From: Sue Howell <Sue.Howell@arun.gov.uk>
Sent: 20 September 2021 16:47
To: Simon Davis <Simon.Davis@arun.gov.uk>
Subject: RE: BN/98/21/DOC

Happy that the information supplied will suffice in the recommendation of discharge of Condition 17 Landscaping.

Subject: BN/98/21/DOC

02 Typical Plot Planting Matrix
L10 1:20 @ A1

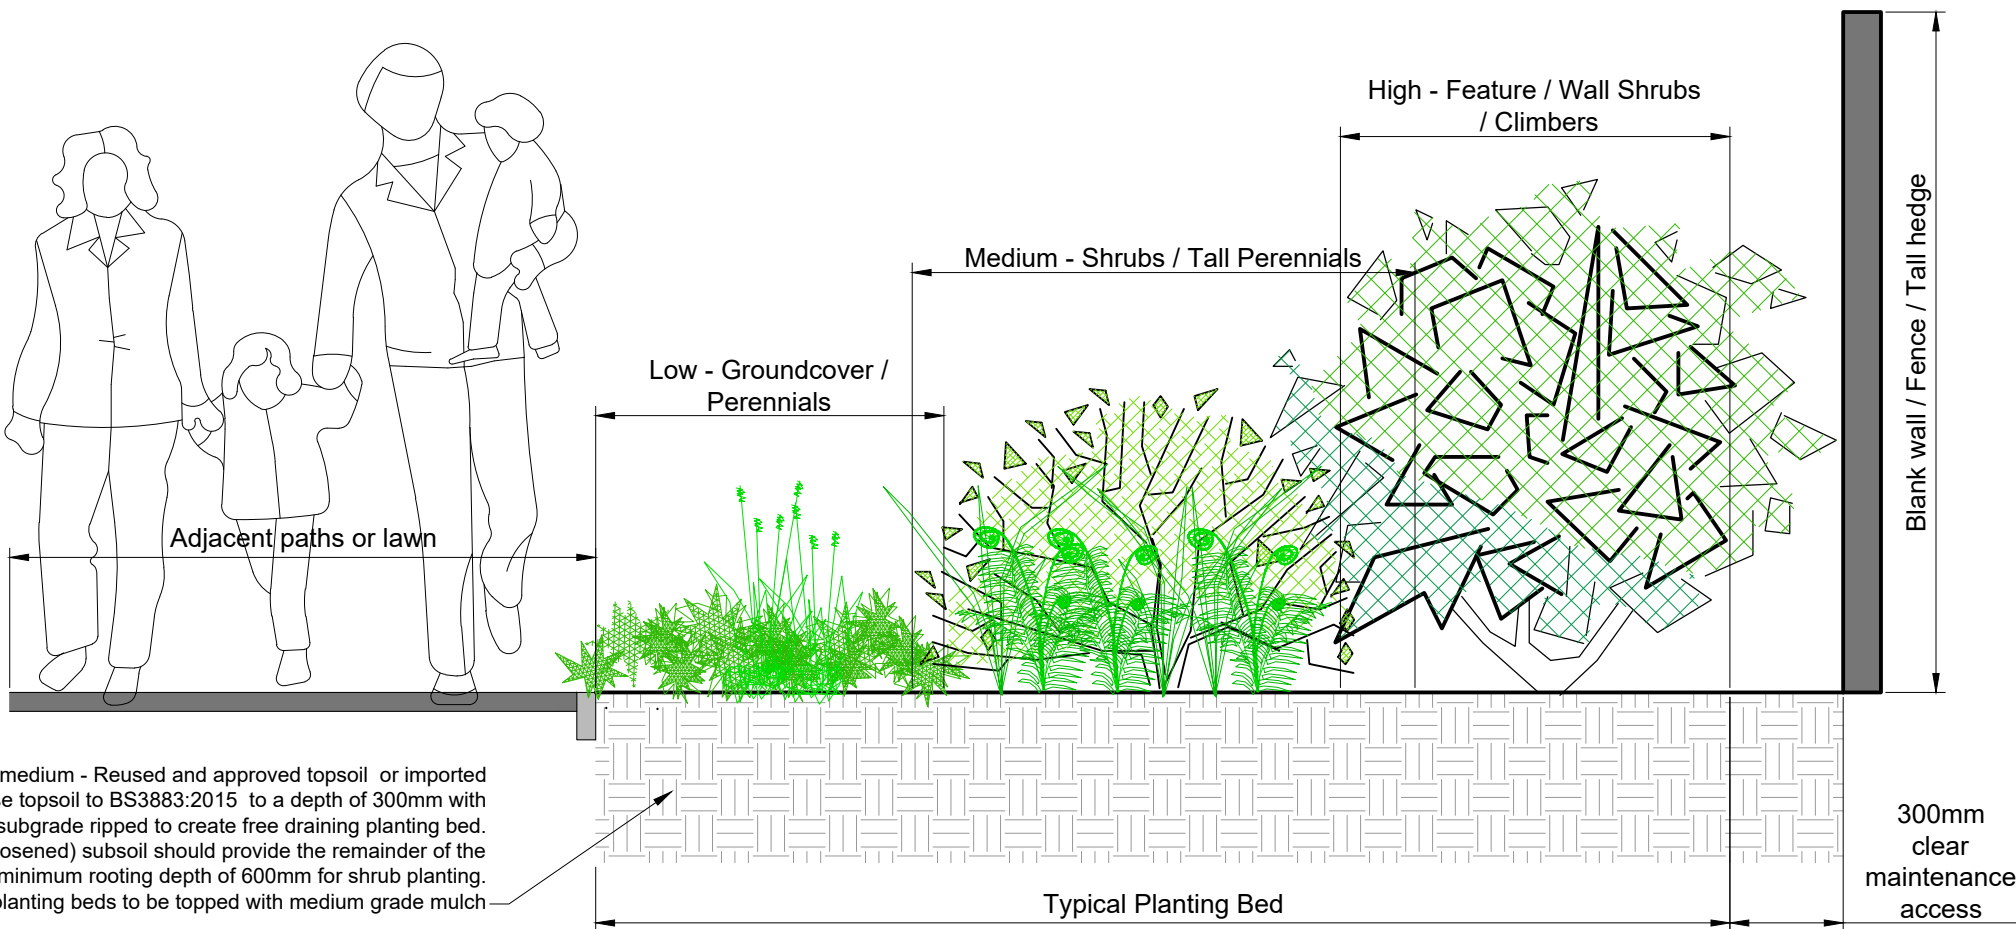
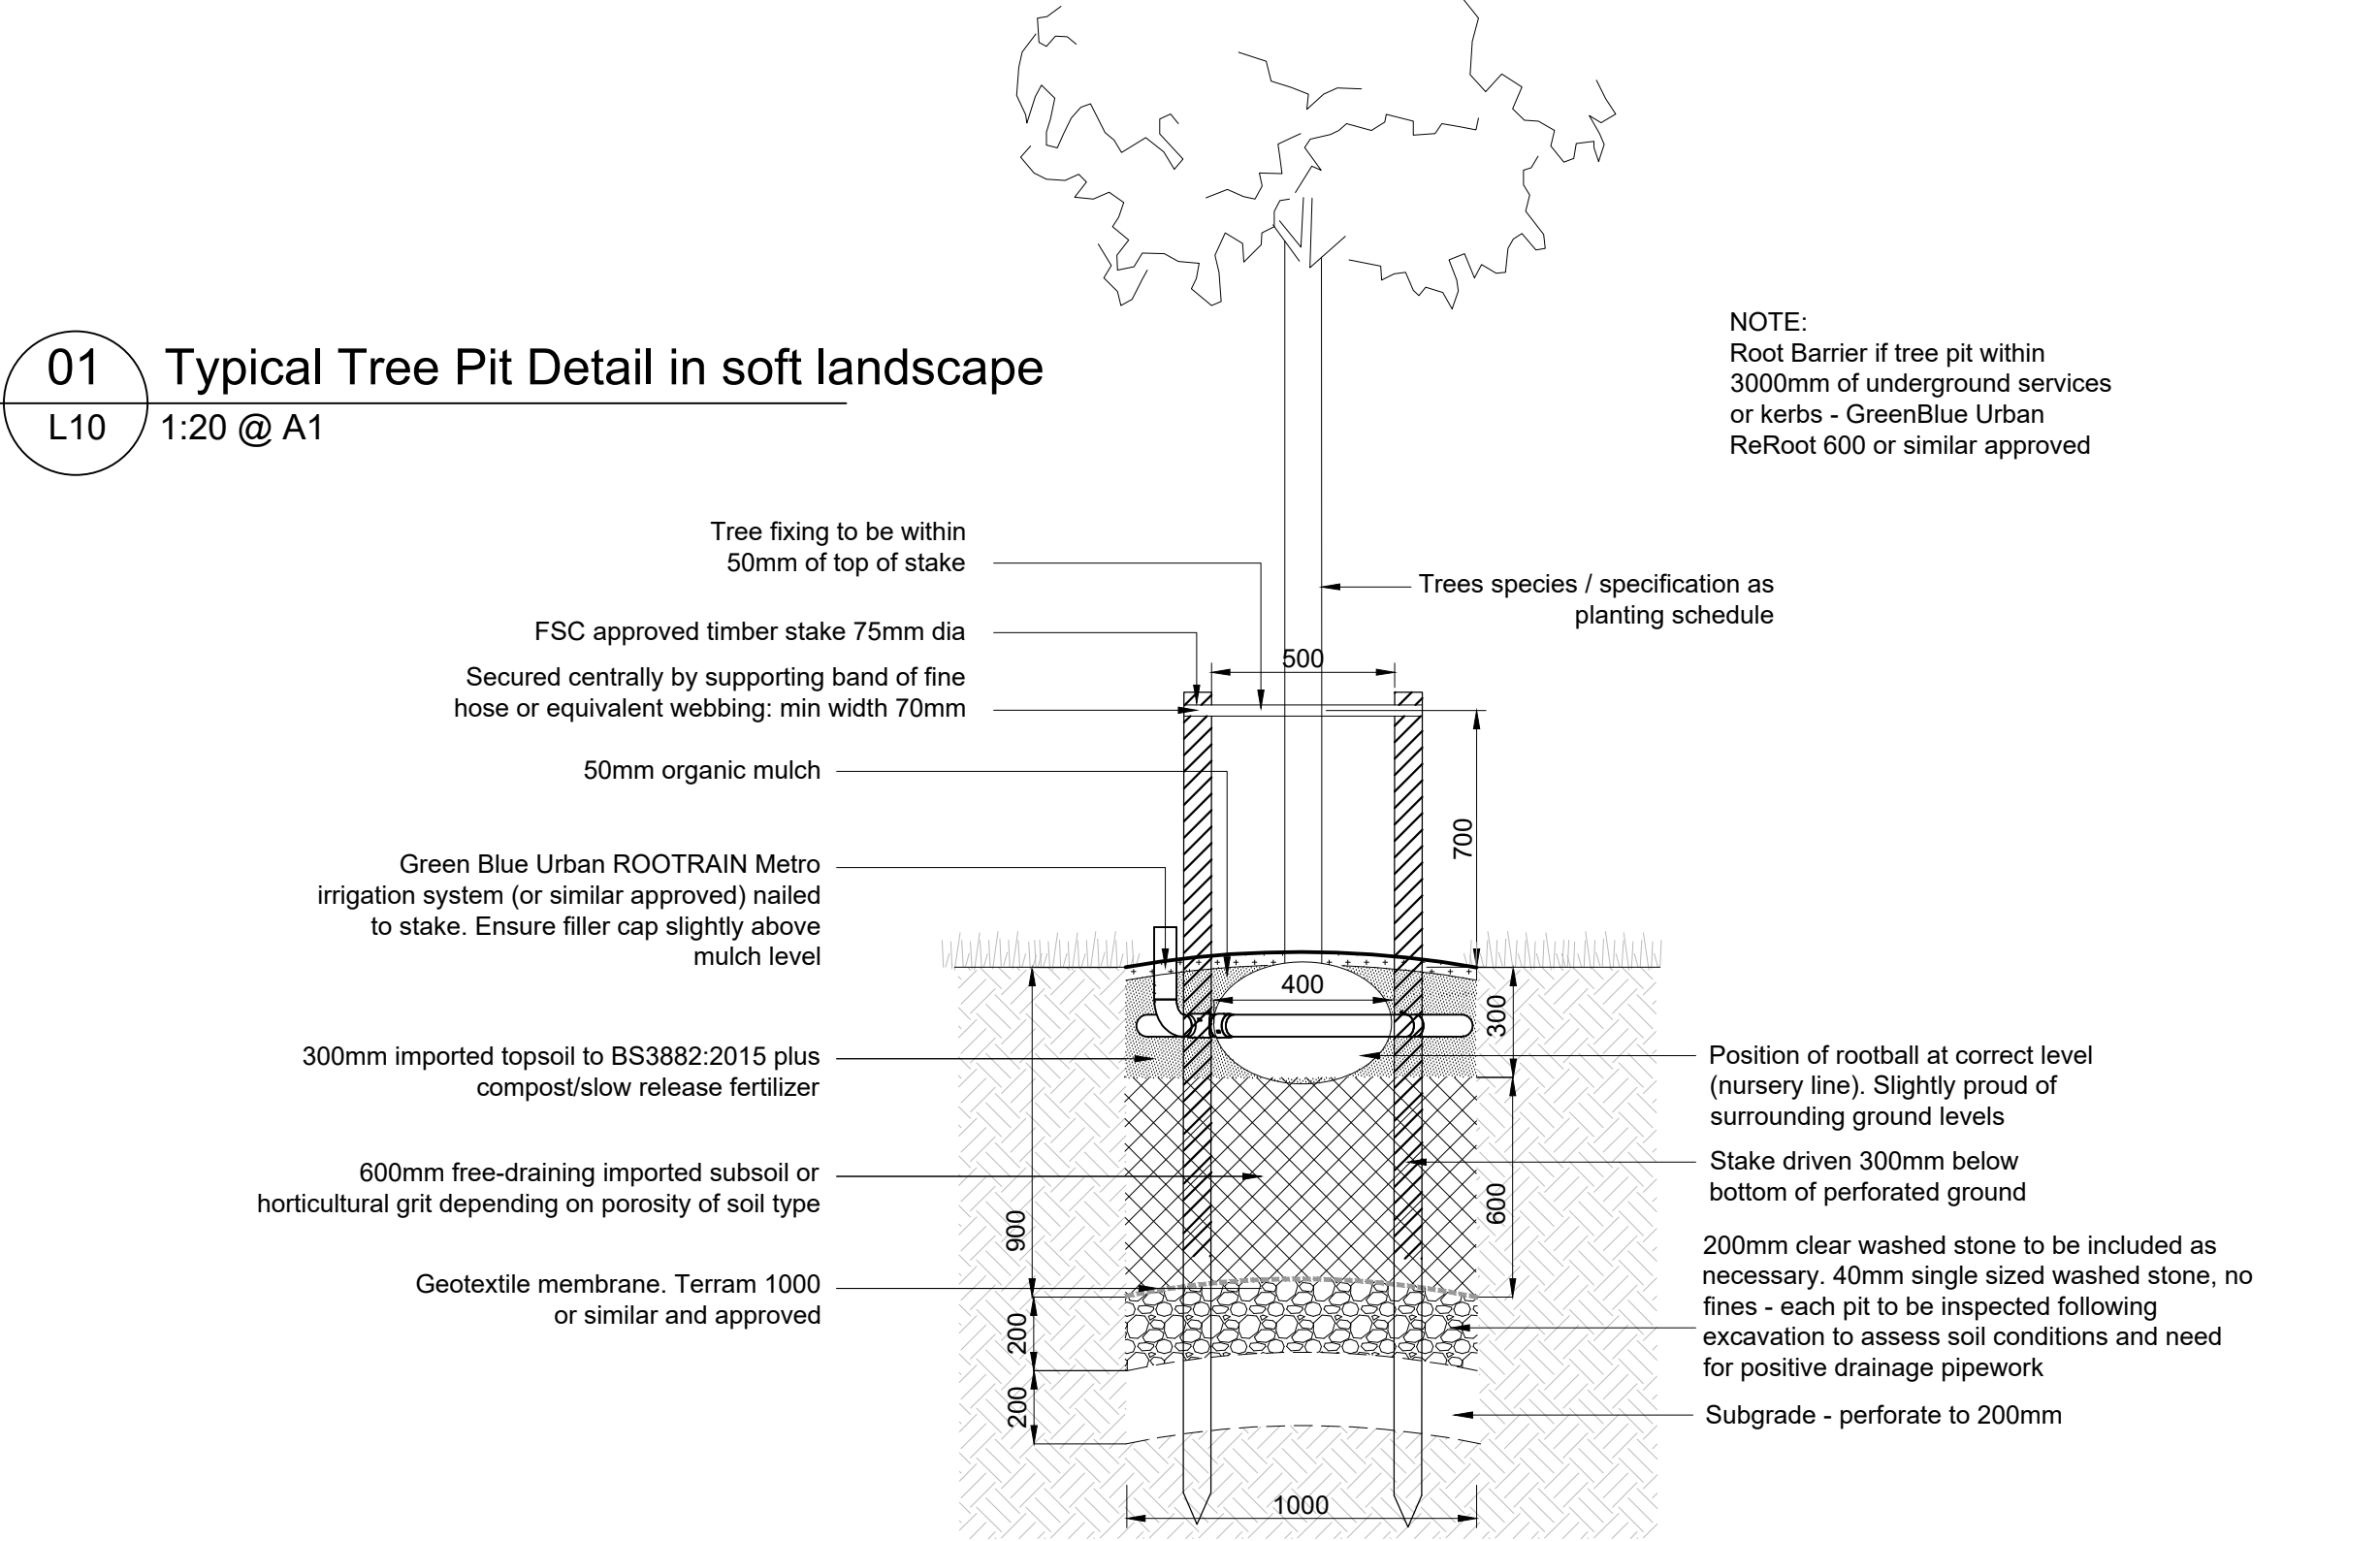
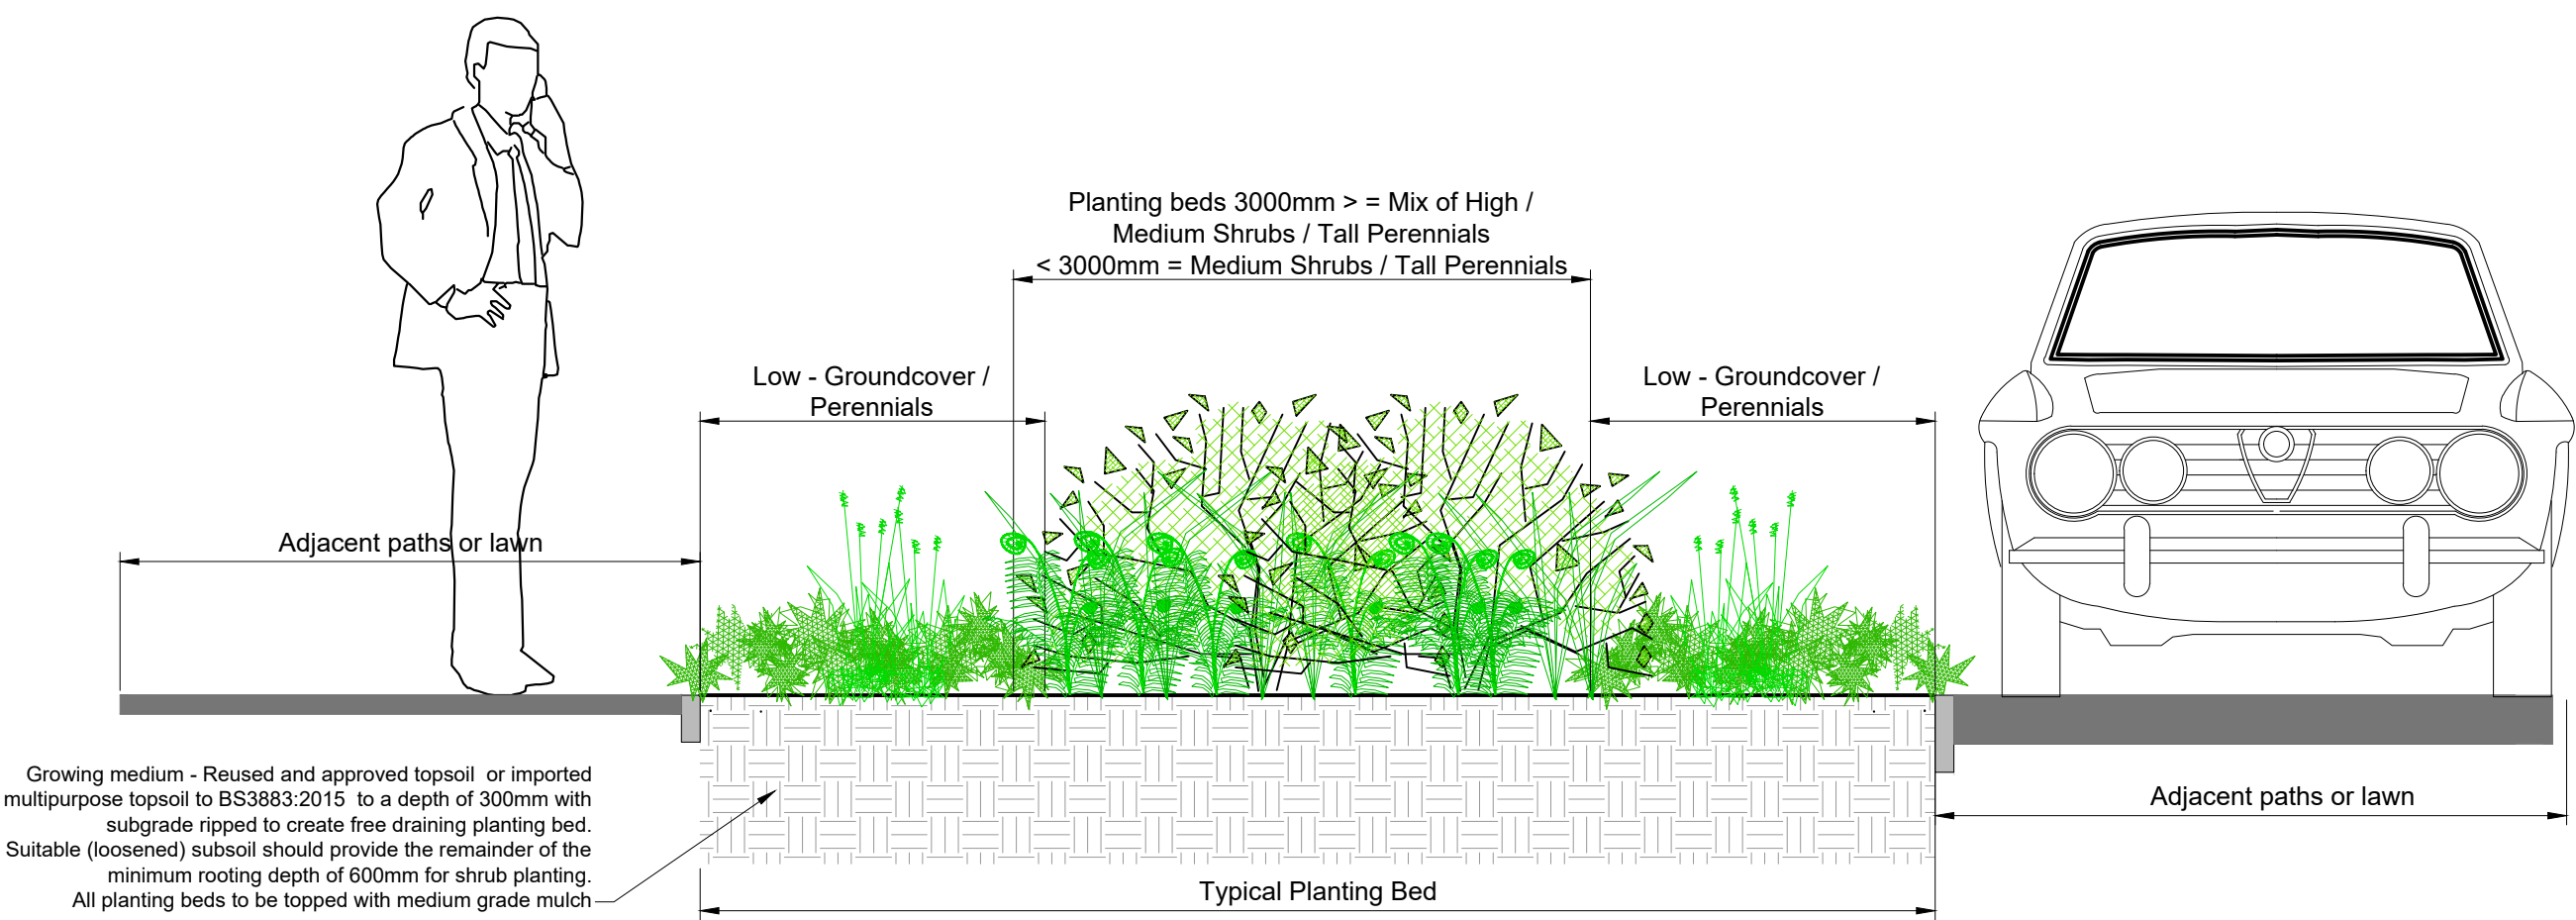
*"The Council's Landscape Officer has agreed the proposed landscaping scheme but comments that the drawings should be amended to show the previously agreed play provision of timber fitness items into the POS areas to the n/west area of the site. The play has now been indicated within the planting plan dwgs referenced as *indicative location of play items* and referenced under dwg Play Element Specification ref DD2276-FAB-00-XX-DR-1-0101 play strategy dwg which does not appear in the drawings listed under this application BN/98/21/DOC but is shown under the outline application BN/50/20/PL play strategy drawing and therefore with both considered would recommend that this element of the condition has been confirmed and met.*

It is also noted that the landscaping condition requires that at least 26 new native trees are provided to include specimens that will potentially grow to 10-15m high. Large trees are indicated but it is unclear what the height of these will be or how many of the tree species are native. The Landscaping drawing refers the reader to DD504L09 for the planting schedule/matrix and general specification but this does not appear to have been provided. The detail provided under this application BN/98/21/DOC in Dwg DD504 L09 Rev B Planting schedule, matrix, Tree Pit Detail and Landscape Specification does supply detail of Tree planning and whilst the required 26no new native trees are not detailed separately they are contained within the schedule of which there are in excess of 26no natives and these are shown as EHS (extra Heavy standards -- which are a 14-16cm girth at time of planting) and therefore the information supplied does conform and therefore I would recommend that this element of the condition has been confirmed and met.

As such, it is not possible to discharge the condition at the current time and we would invite you to make a resubmission which (a) includes the timber fitness items on the drawings and (b) clearly demonstrates compliance with the specific requirements of the condition.”
